**Request for SEARs – SSD 8606 – Proposed Industrial Warehouse Estate – Lots 23 & 24
Hollinsworth Road, Marsden Park, Blacktown**

CONSTRUCTION OF WAREHOUSING ESTATE – HOLLINSWORTH ROAD, MARSDEN PARK

Warehousing Estate - Hollinsworth Road, Marsden Park, Blacktown (SSD 8606)

Project: SSD 8606 Warehousing Estate – Hollinsworth Road, Marsden Park
Construction and operation of a warehousing and distribution
estate at Lots 23 and 24 DP 262886

Drawing Title
BUILDING 3: WAREHOUSE PLAN

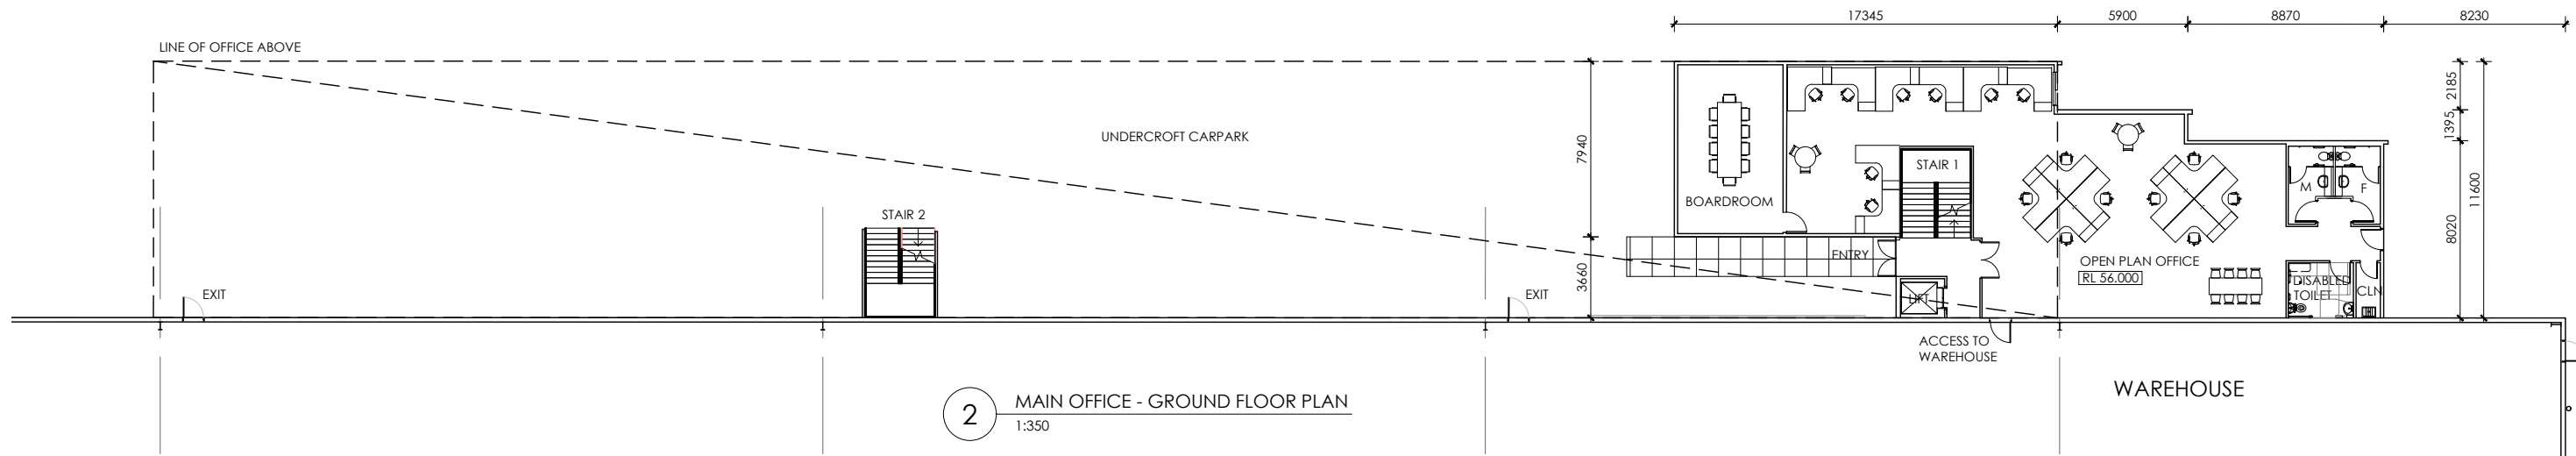
Consider the development site is within close proximity to Oakhurst residential area and to the caravan park estate across the road, proposed Building 3's 30m high-bay area raises issues of visual impact and architectural merit that the NewCold raised. It is required that a Clause 4.6 variation be submitted and considered. The Clause 4.6 variation shall justify why it is in the public interest to allow the high bay and what is the better planning outcome of allowing the high bay to exceed the height limit.

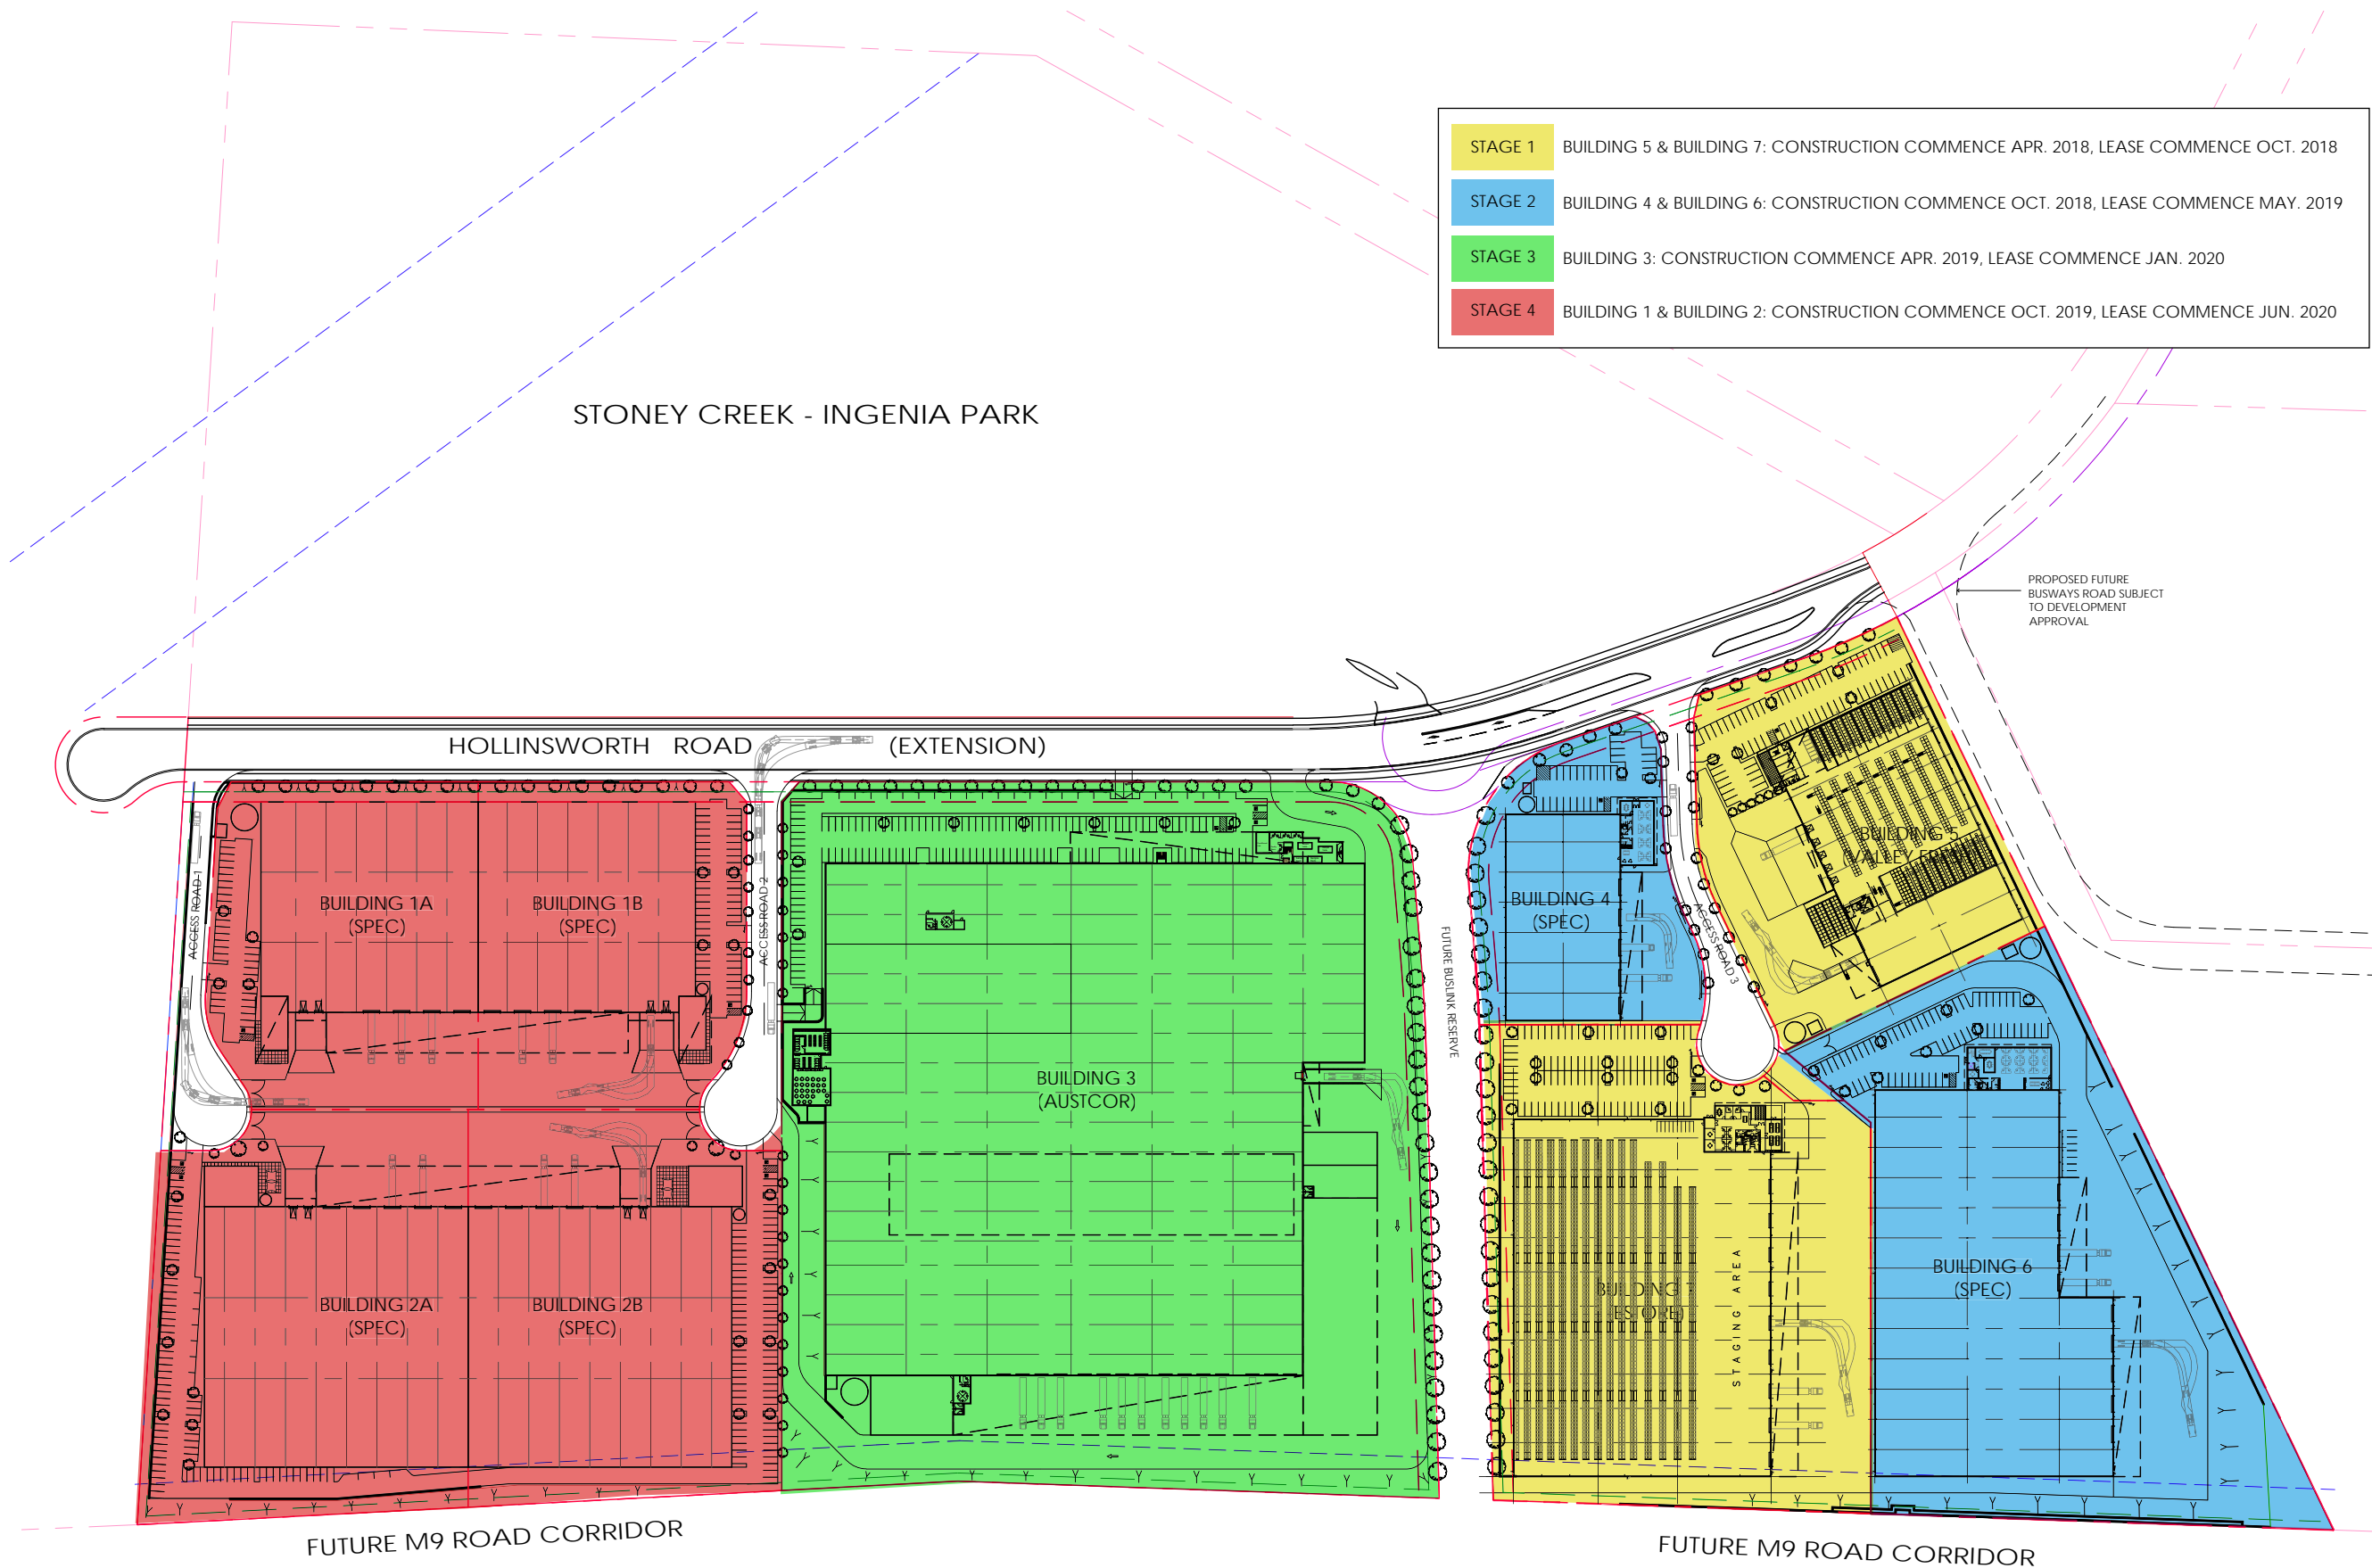
The preliminary Masterplan provided shows the Hollinsworth Road extension crossing under TransGrid's lines. In accordance with *State Environmental Planning Policy (Infrastructure) 2007*, TransGrid must undertake a technical assessment of potential safety risks of the road undercrossing to ensure the safety of the public. TransGrid also needs to assess the impacts of the proposal on TransGrid's assets.

Please find attached the TransGrid *Easement Guidelines for Third Party Development* and the WorkCover NSW *'Work Near Overhead Powerlines'* Code of Practice 2006. The distance between the proposed road and the transmission lines must comply with the AS7000 minimum vertical clearance requirement.
